**Consultation Response from KC,
Lead Local Flood Authority**

2024/92444 Land North of, Denby Lane, Grange Moor, Huddersfield, WF4 4BH

Erection of 21 dwellings and associated works with means of access from Denby Lane

Date Responded: 07/01/2025.

TITLE  
**S104 DRAINAGE LAYOUT**

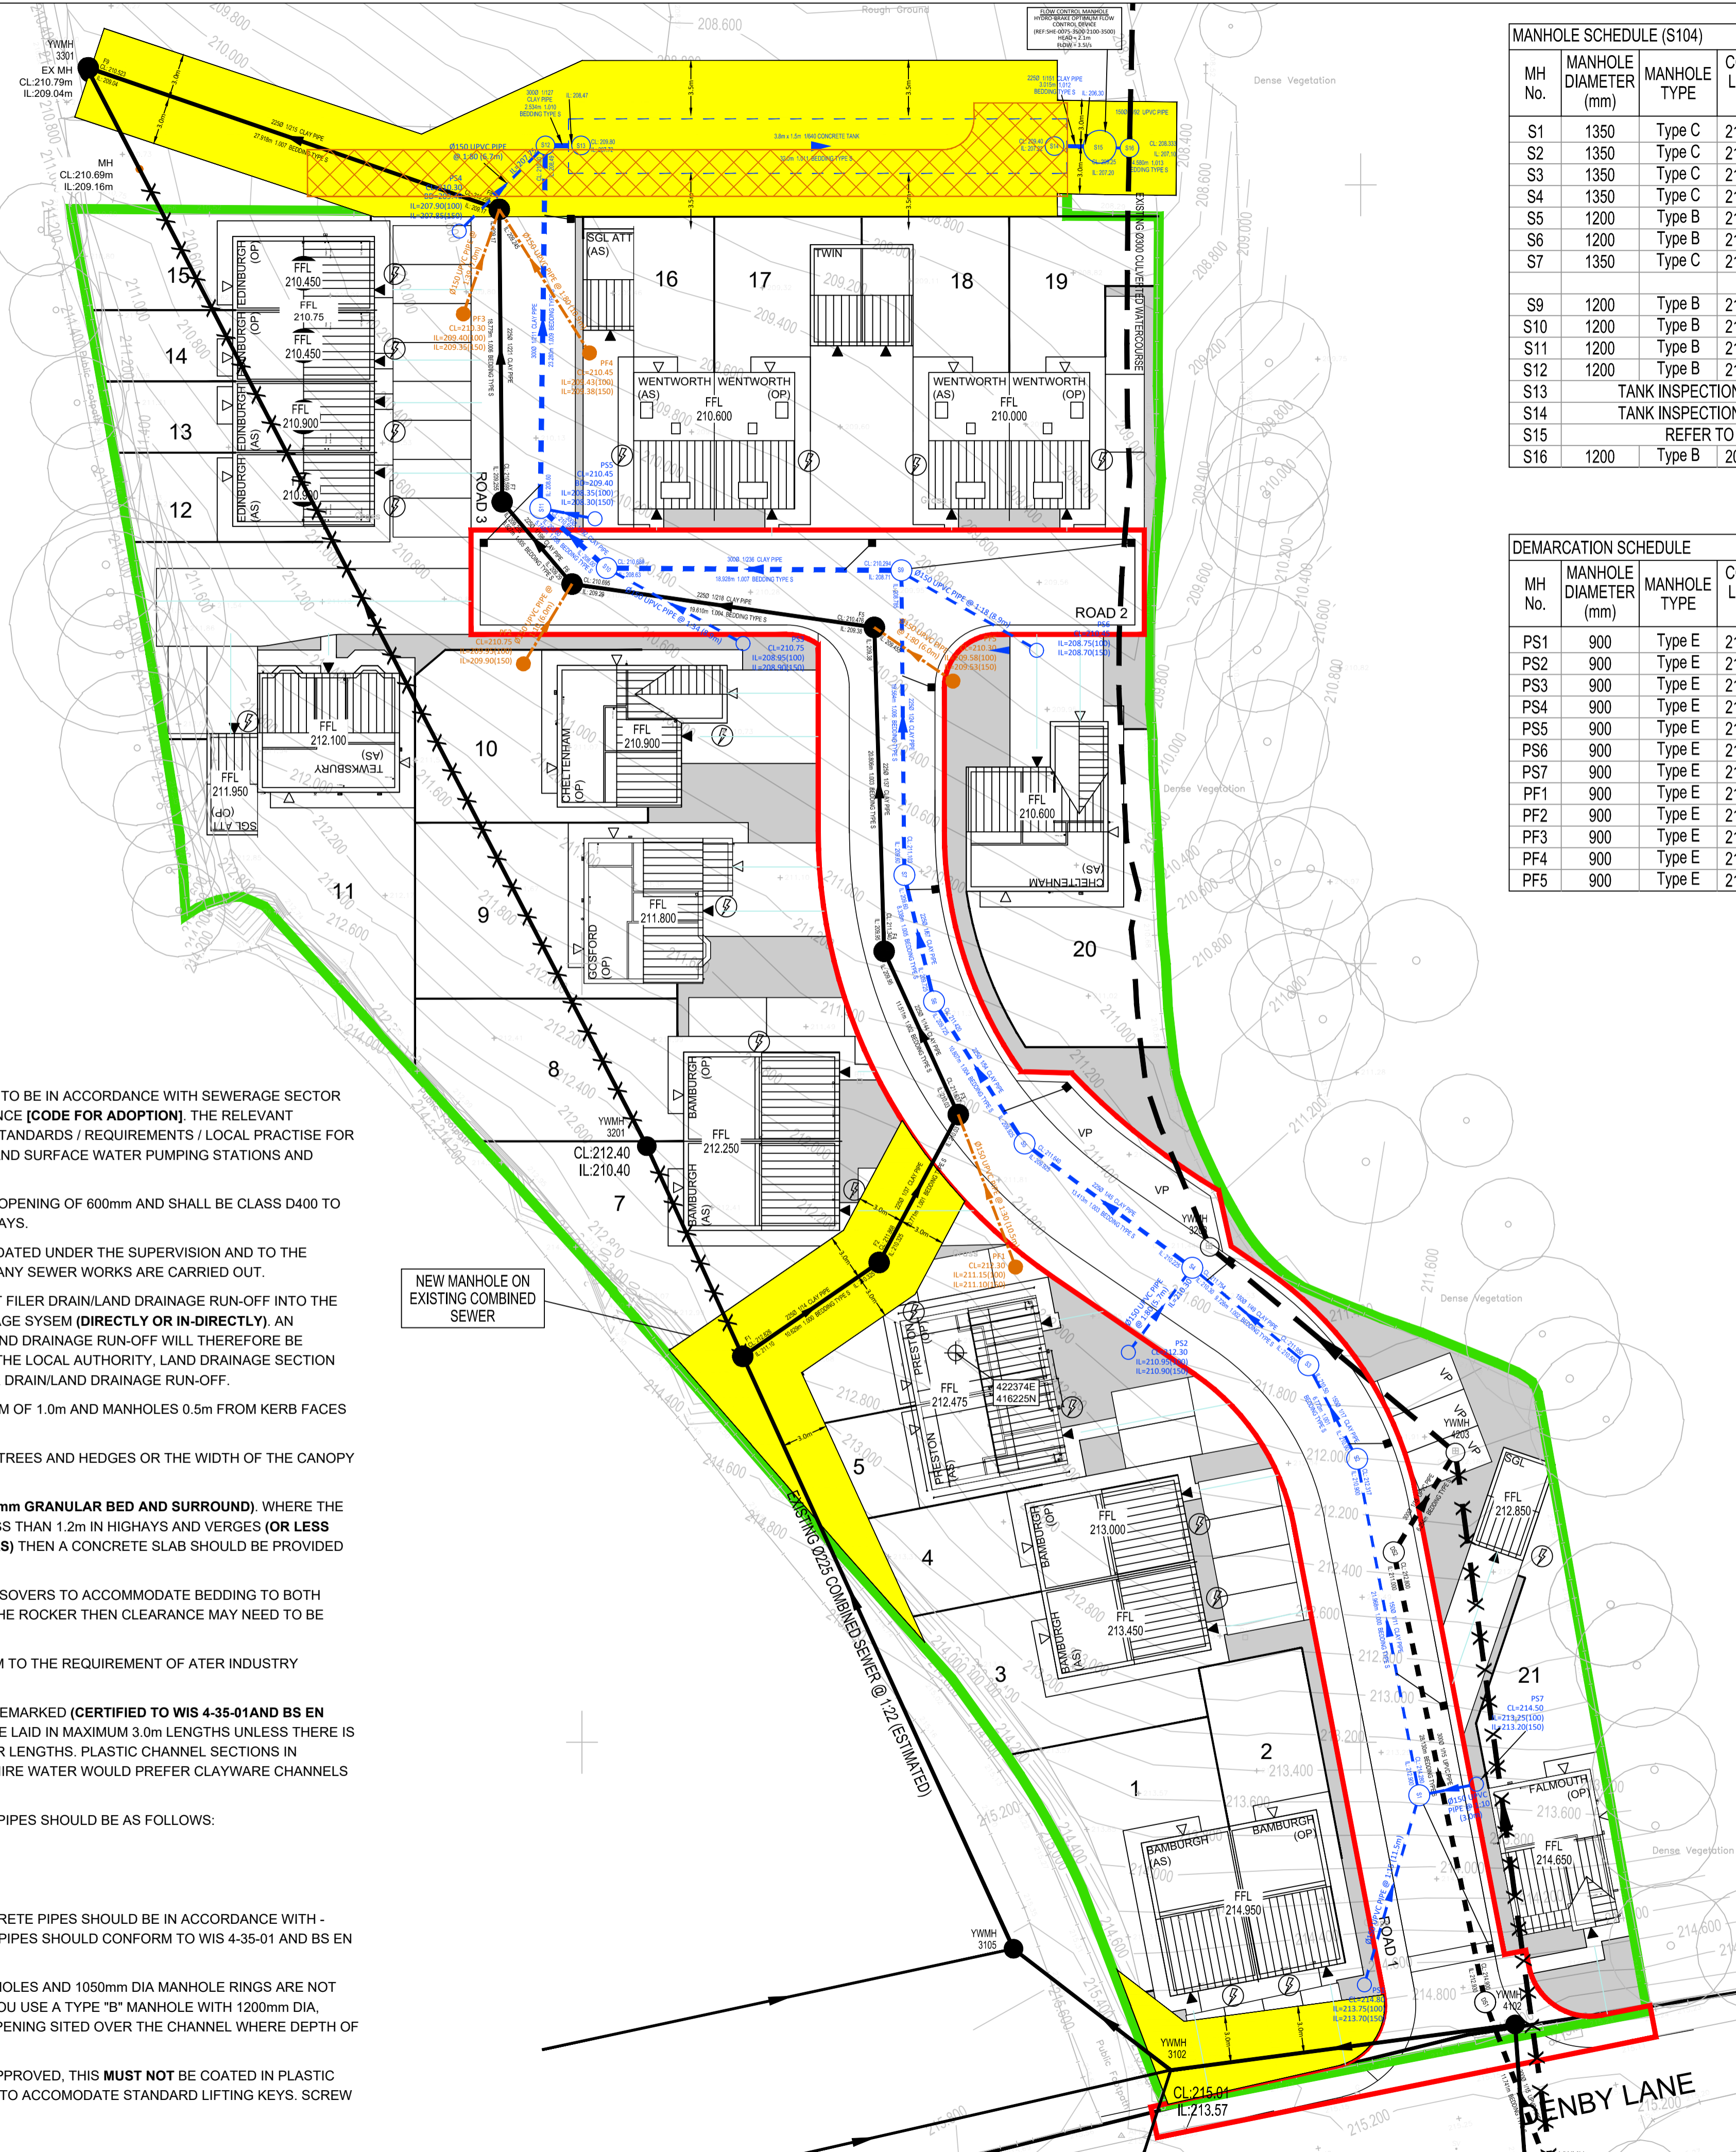
The LLFA confirms that the drainage layout is generally acceptable, however the following points will need to be addressed:

- hydraulic calculations should be submitted to confirm that the attenuation storage is sufficient to prevent off-site flooding during the critical 1 in 100 year (plus CC) rainfall event,
- details of the concrete tank need to be submitted, and these should indicate that a low flow channel is provided to reduce the risk of siltation within the tank.
- details of the new manhole over the existing culvert where the attenuated surface water outfall from the site is connected – this is a requirement for Land Drainage Consent purposes which can be approved as part of the Planning Application,

Note that the above requested information for construction phase and permanent drainage can be submitted at the discharge of consent stage, the proposed drainage conditions contained in the LLFA's consultation response dated 01/11/2024 are still valid.
